# Immingham Green Energy Terminal

10.7 Proposed Further Changes Notification Report

Document Reference: TR030008/EXAM/10.7

Drawing Number	Project	Originator	Volume	Rev
60673509	-ACM	-XXX	-	P02
Location	Type	Role	Number	
ZZ	-DR	-CH	0002

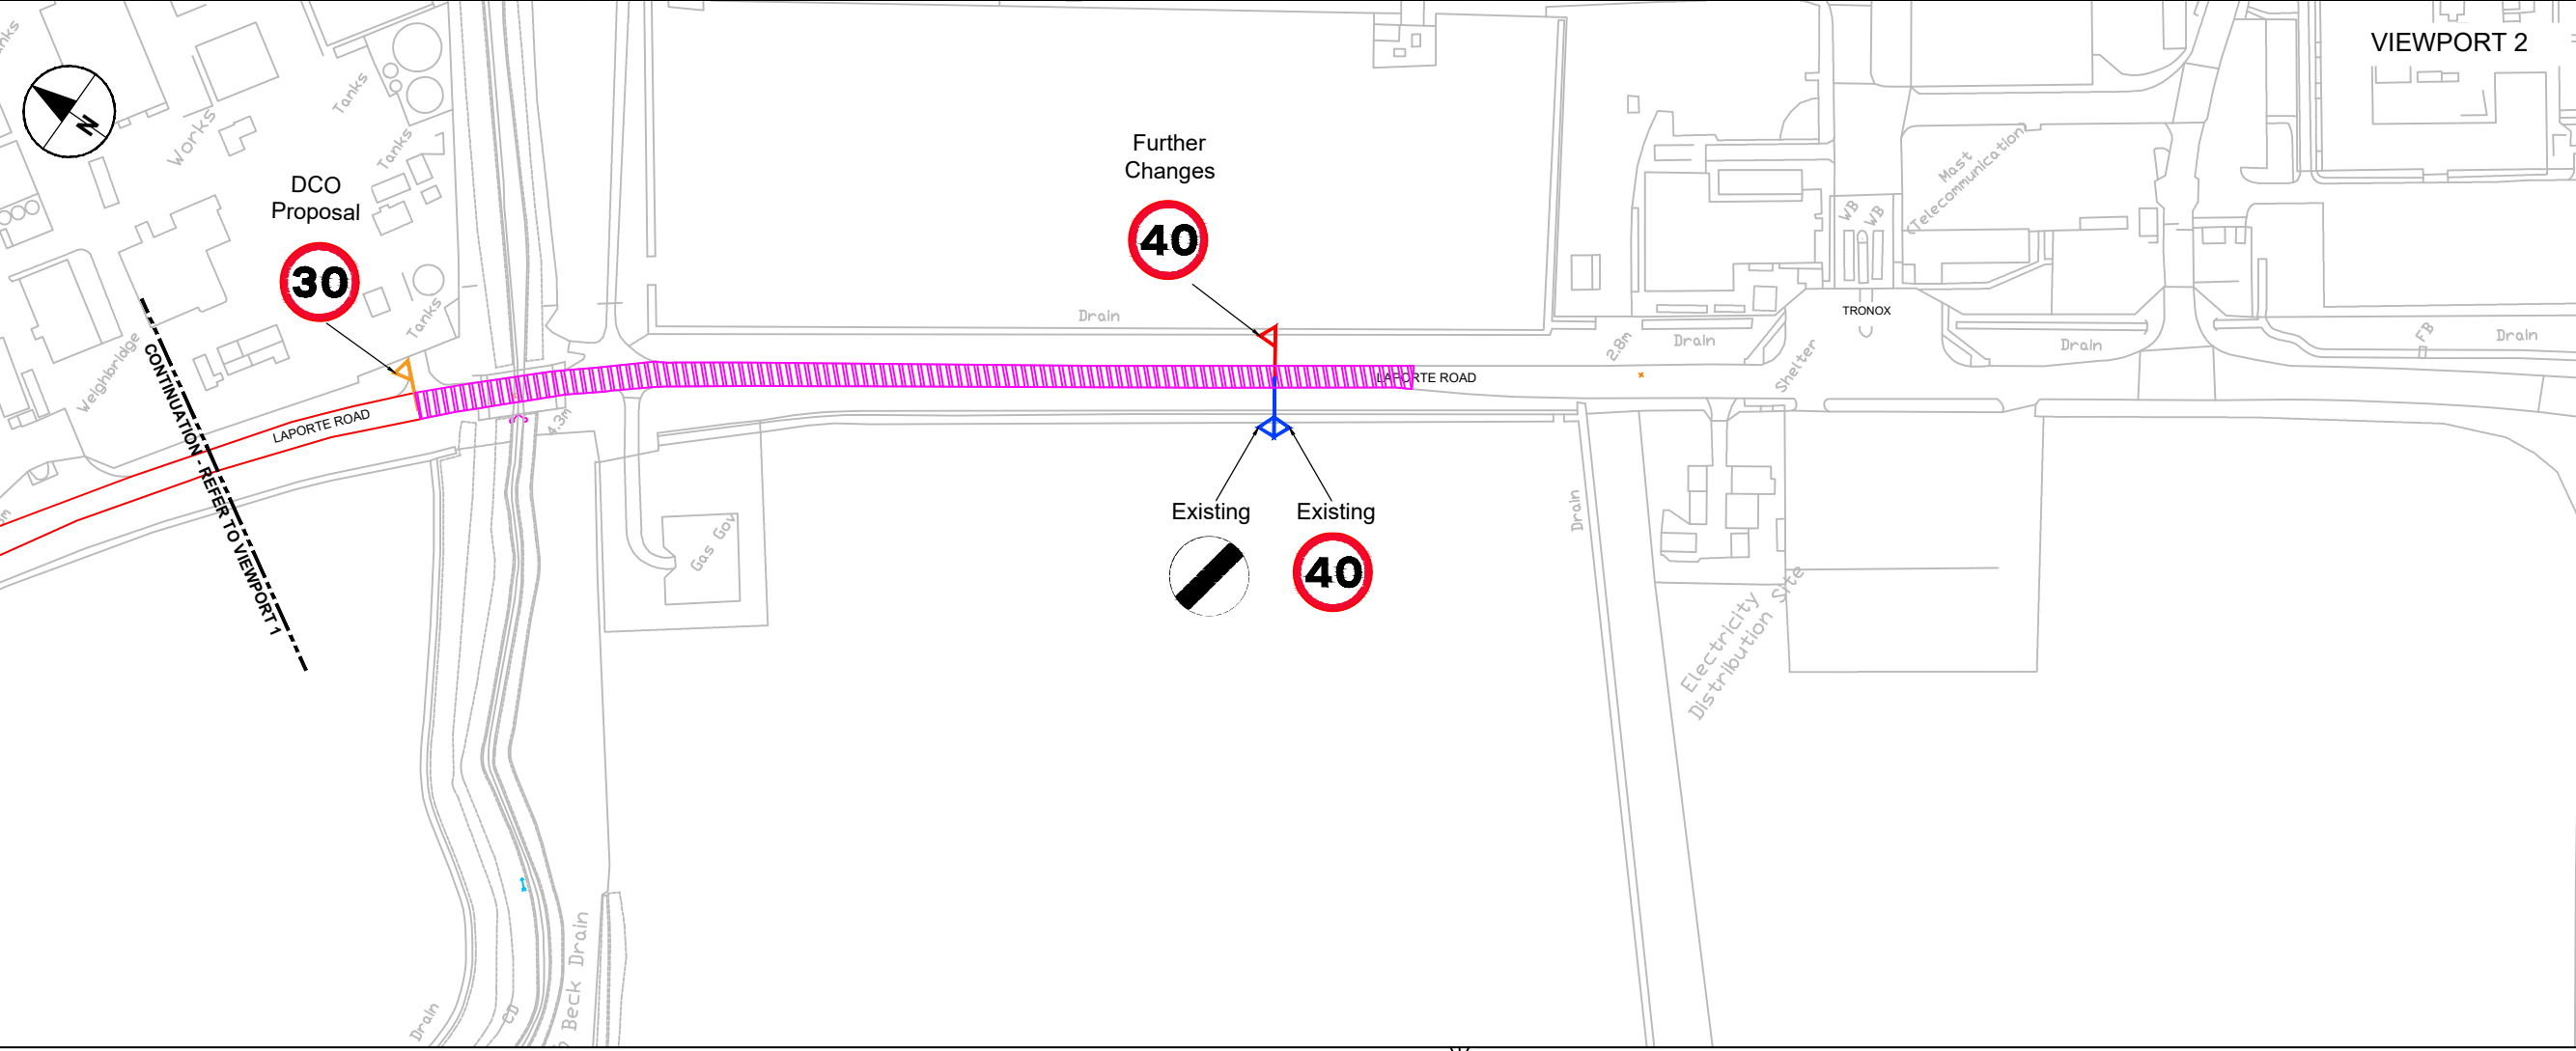
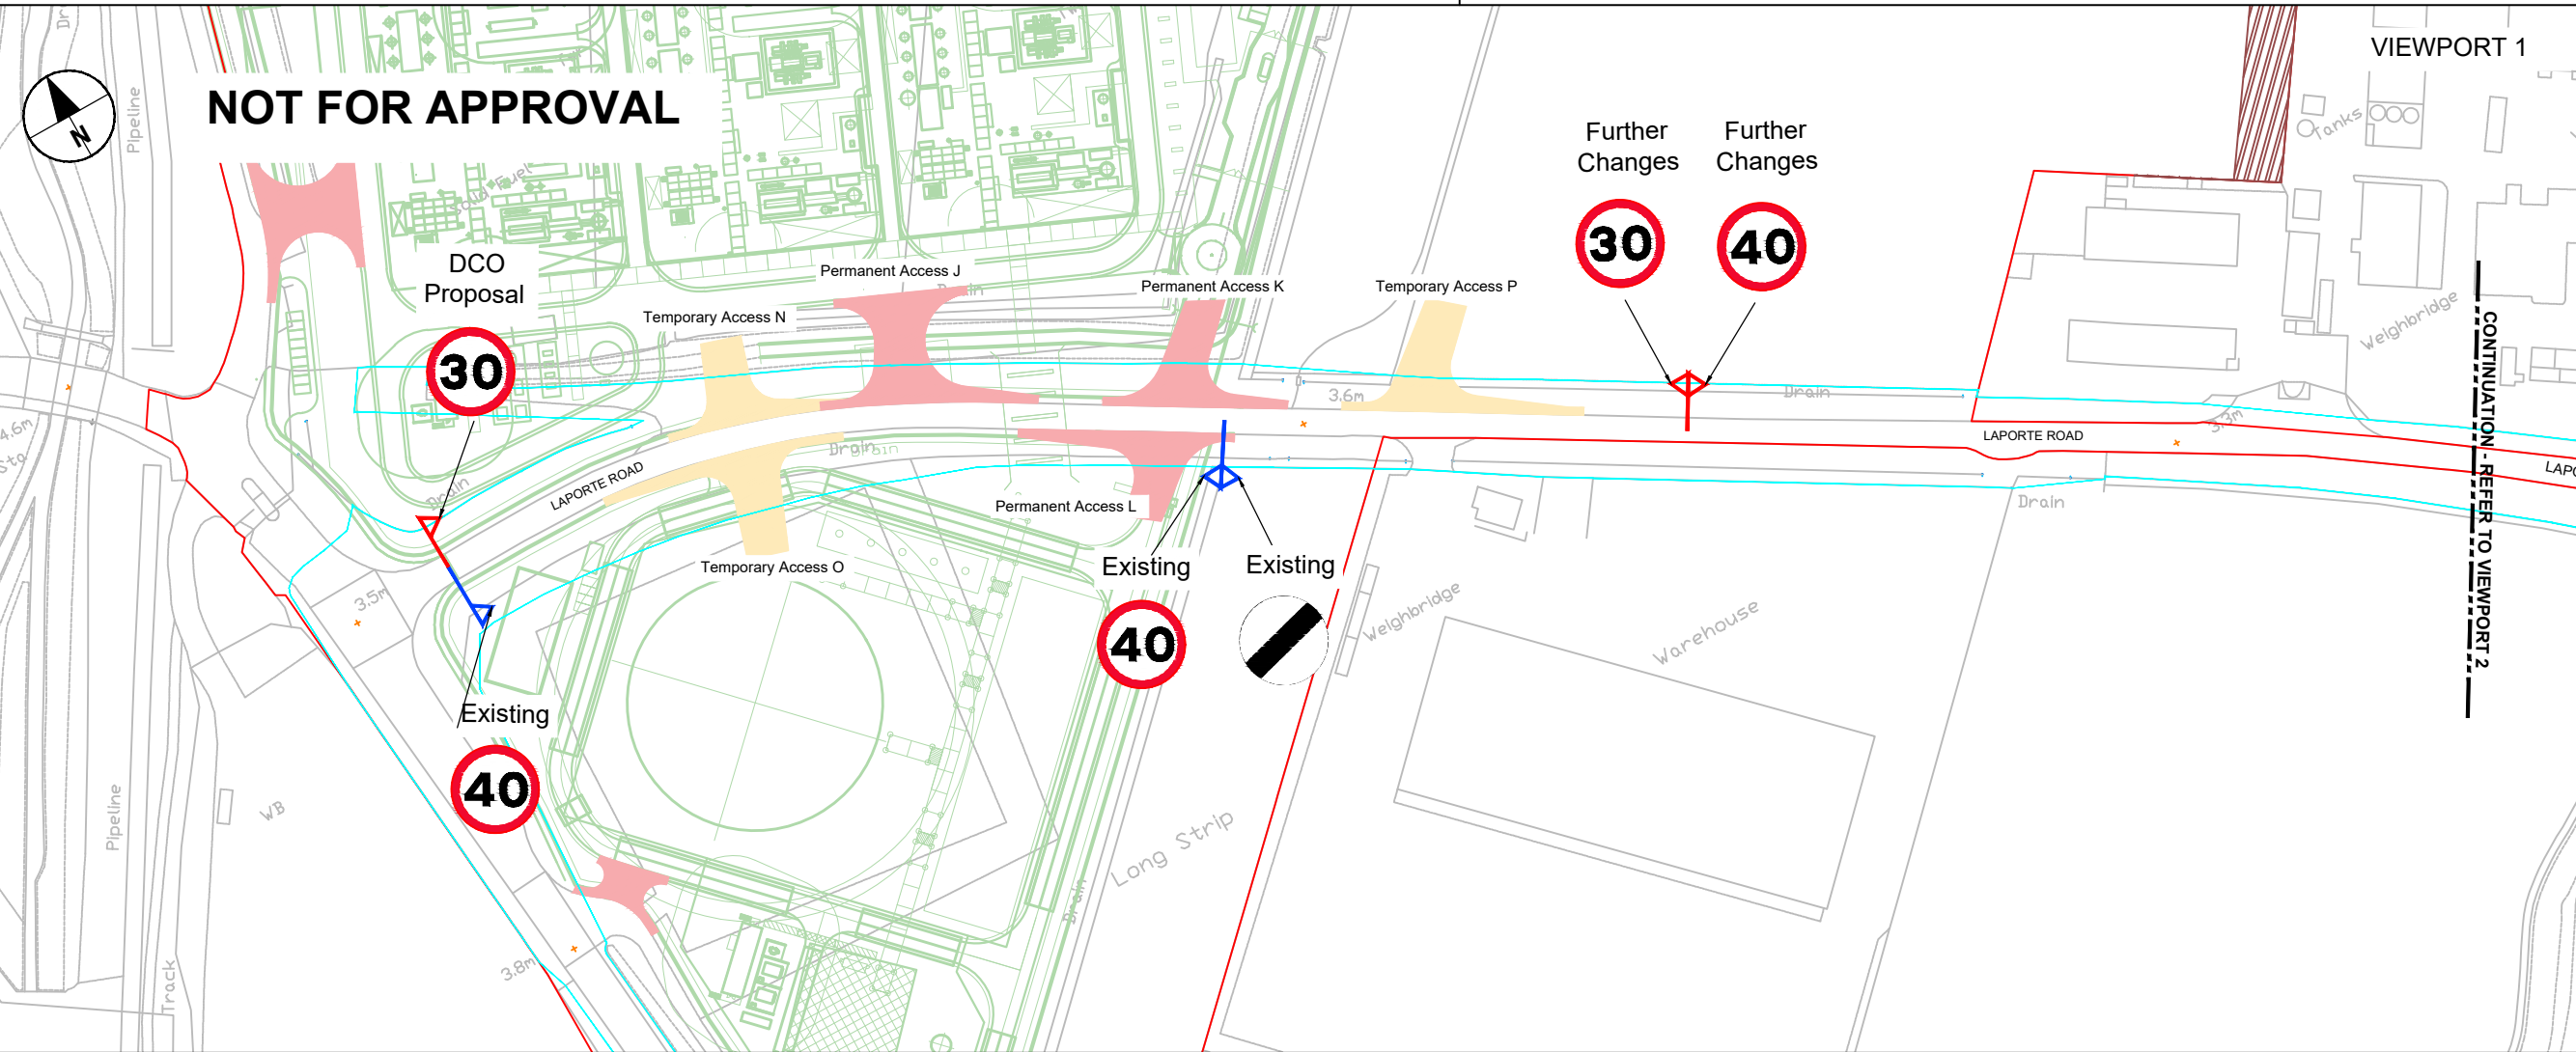
- 2.5.2 NELC Highways has requested that the limits be consolidated in order to better reflect existing controls and to remove what would be a short section of 60mph limit, thereby smoothing the speed limit changes.

- 2.5.3 It is therefore proposed that the 30mph limit will apply to Laporte Road between the junction with Queens Road and the eastern extent of Access P (Access P is shown on the **Street Works and Accesses Plan [REP3-016]**). A limit of 40mph is proposed from the eastern extent of Access P for approximately 600m to the point where the existing limit on Laporte Road reduces to 40mph. This will require a short extension (approximately 305m) of the Order limits along the public highway of Laporte Road to encompass the new 40mph section. **Appendix 1** illustrates the location of the proposed change. **Appendix 2** illustrates the proposed adjustments and the proposed extension to the Order limits to reflect Proposed Change 5(c) and **Appendix 4** illustrates the locations of the proposed changes to speed limits.
